APPLICATION FOR PERMIT HEATING OR POWER EQUIPMENT

Re: 661 Allen Avenue, Permit # 07-1319
CBL: 398-B-016001

The above referenced permit application is denied pursuant to Section 105.3.1 of the International Residential Code 2003. The information requested has not been submitted in order to approve a compliant installation:

PROPOSED STOVE PIPE INSTALLATION

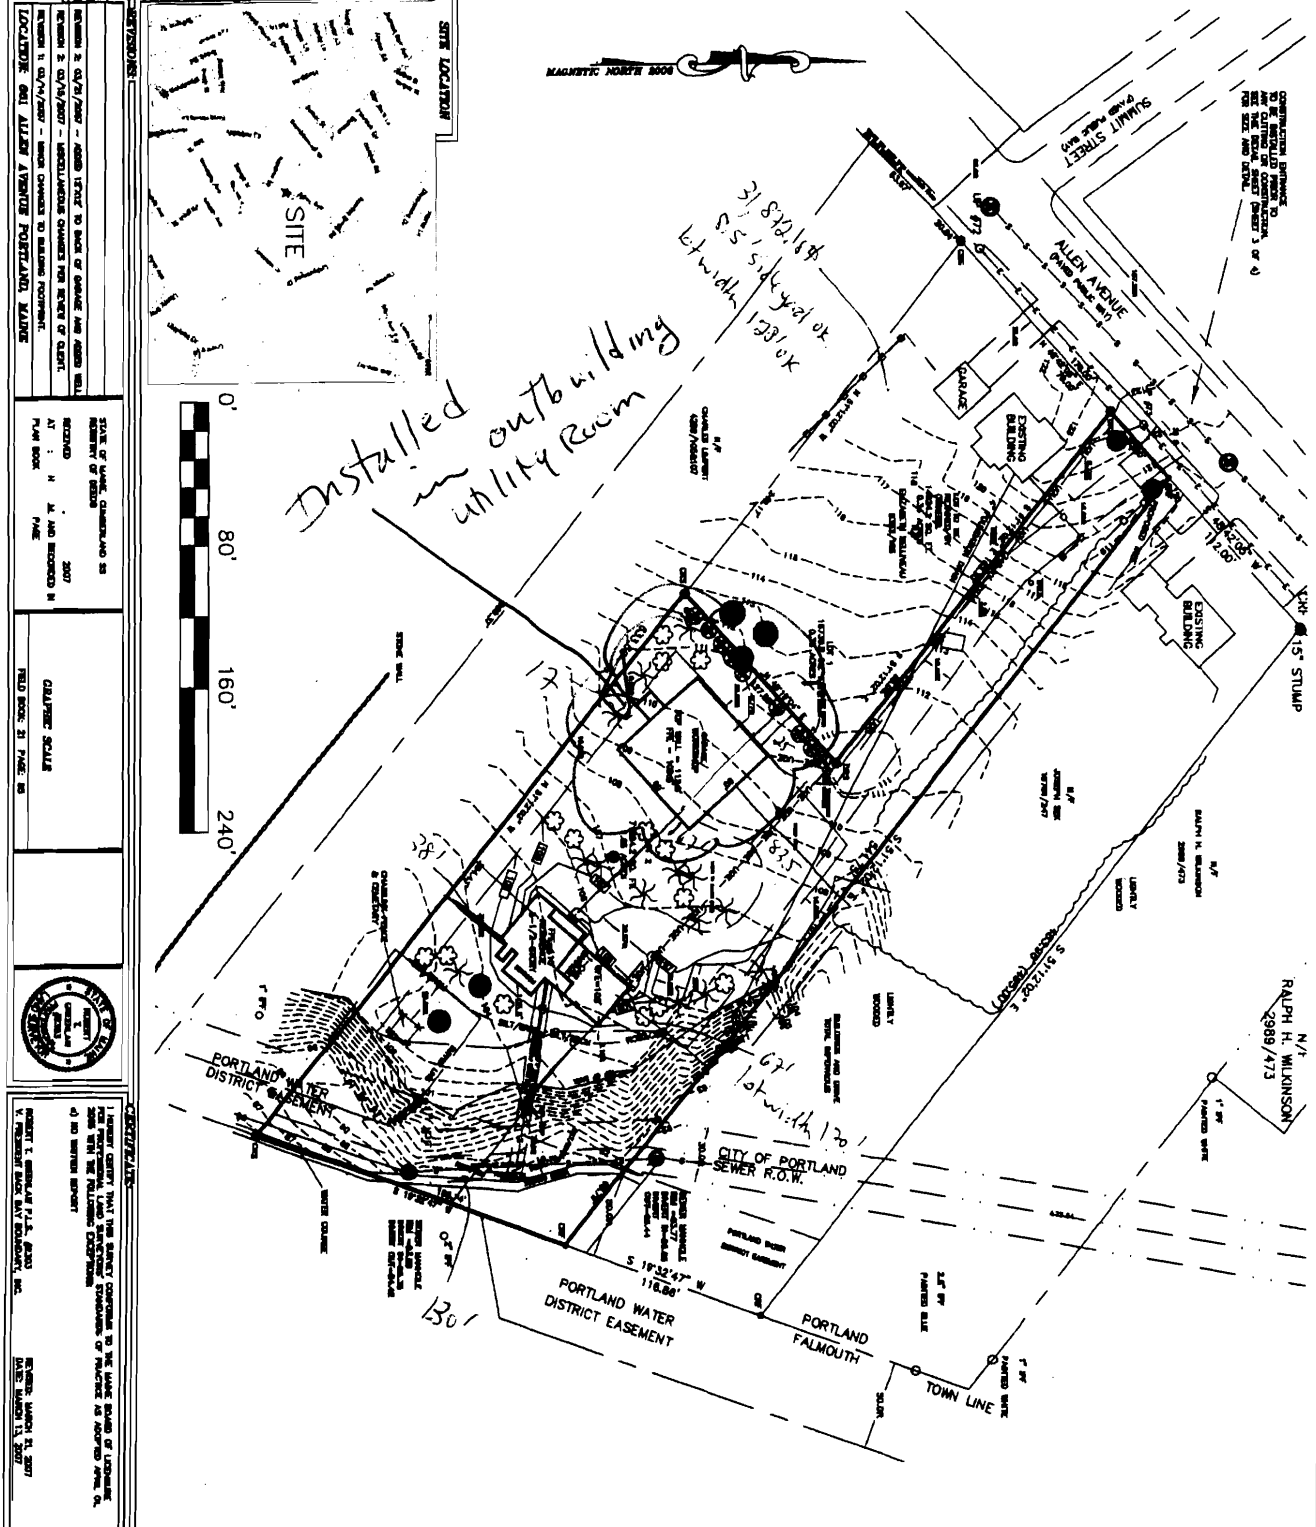
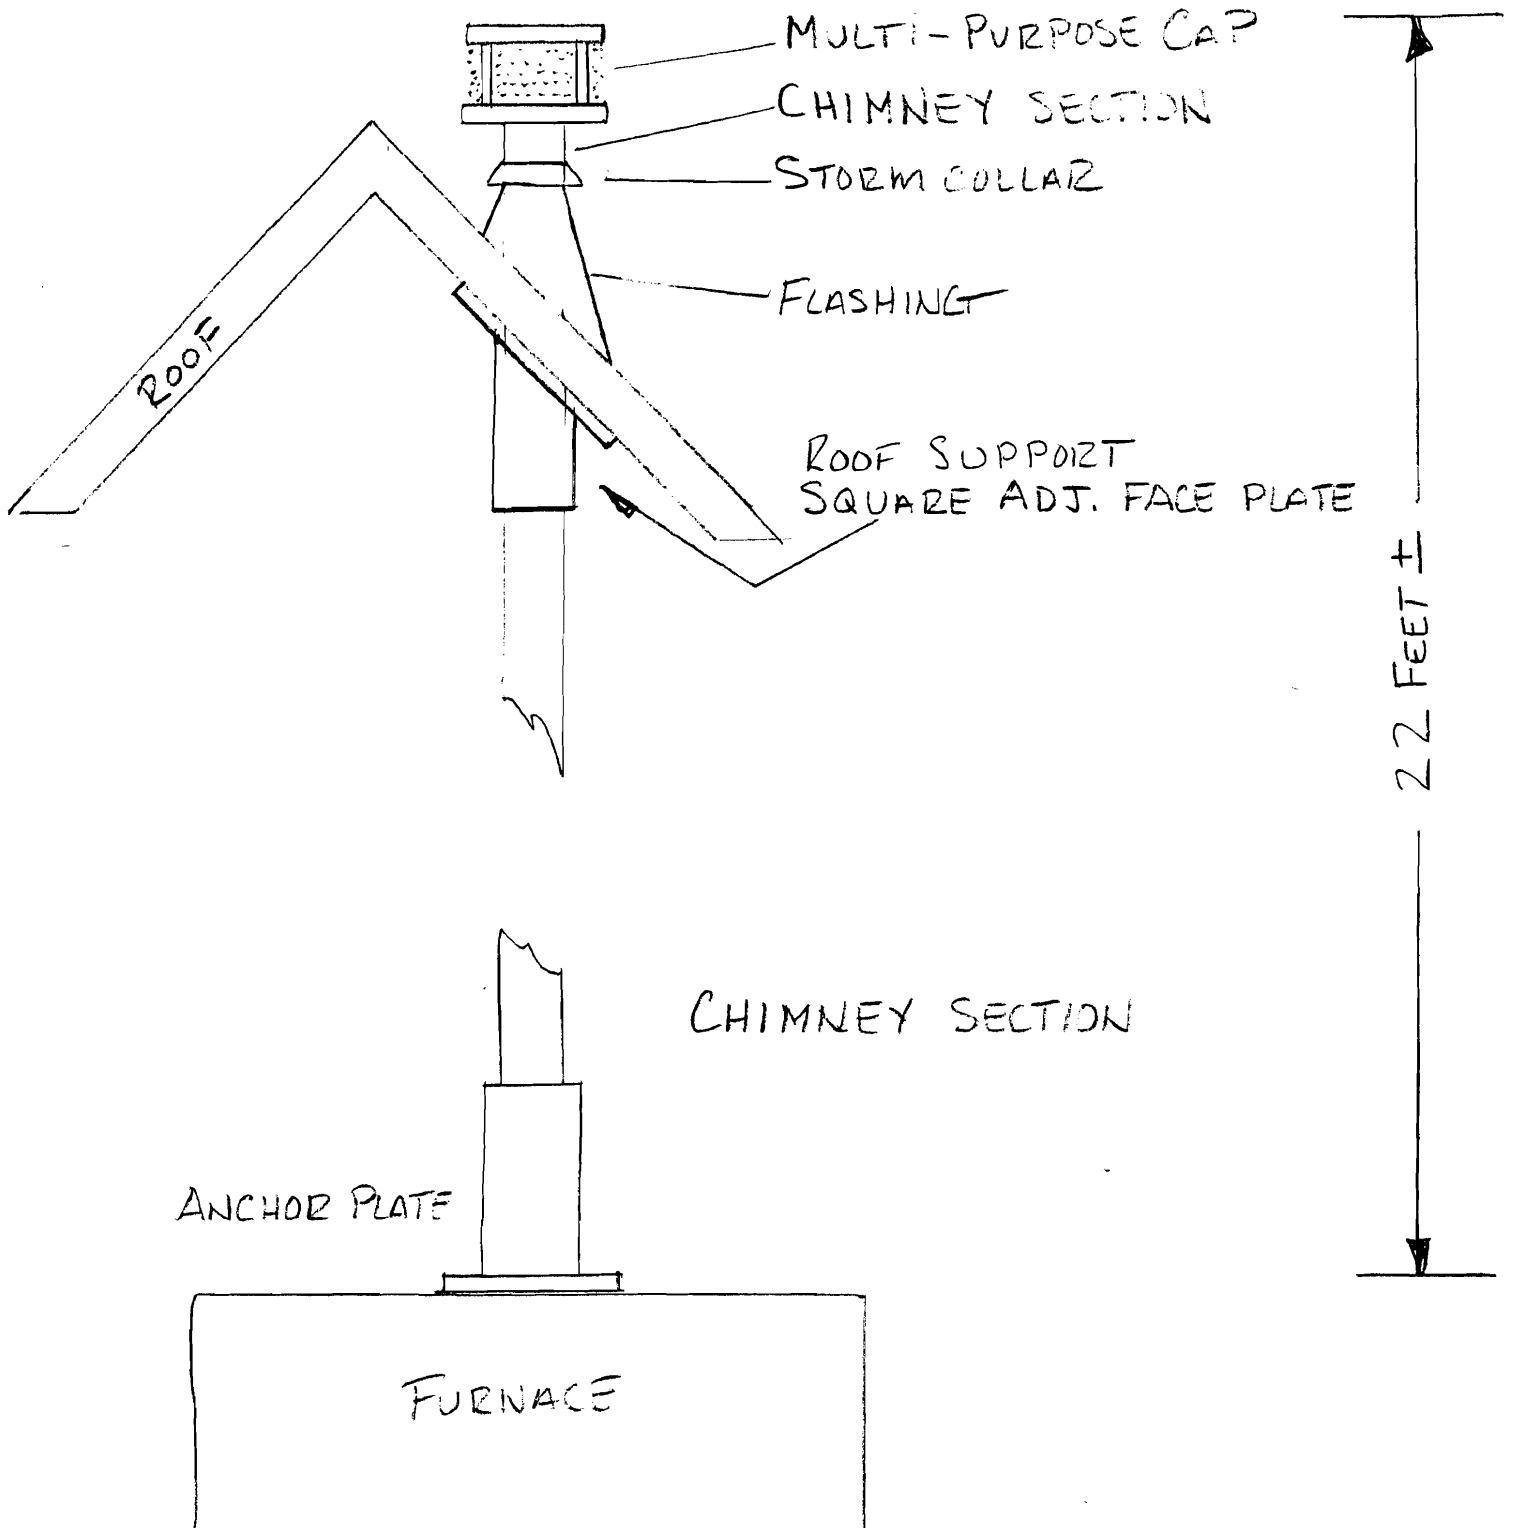
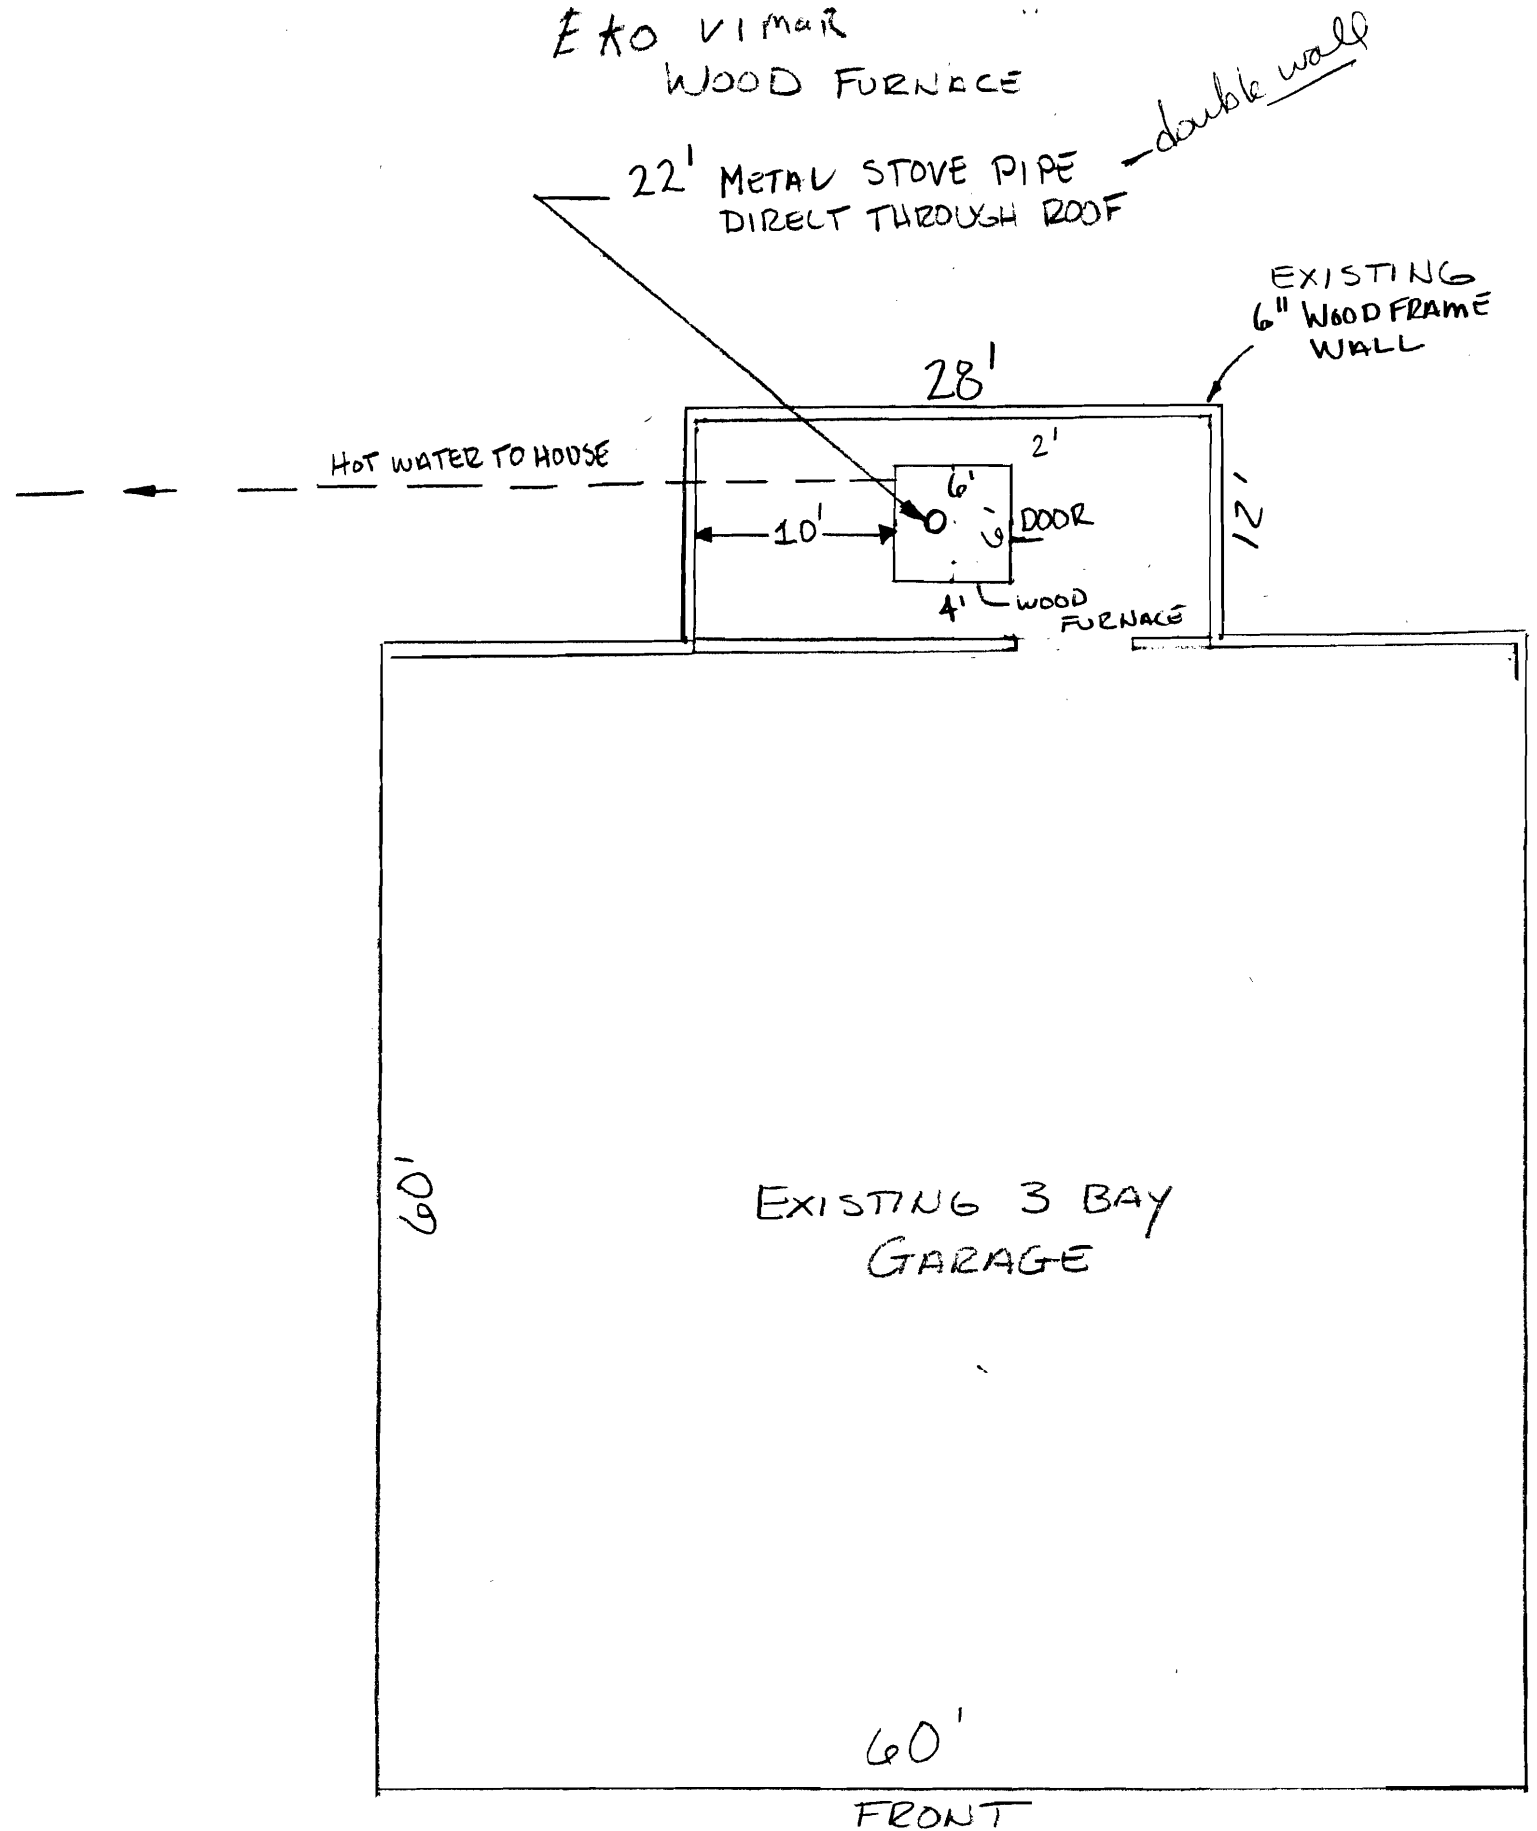
1. Accurate verification of required clearance to combustibles or compliant reduction method
2. Certification that the appliance meets DEP emissions control standards, setbacks to property lines and smoke stack heights.
3. The extension pipe/stack specifications
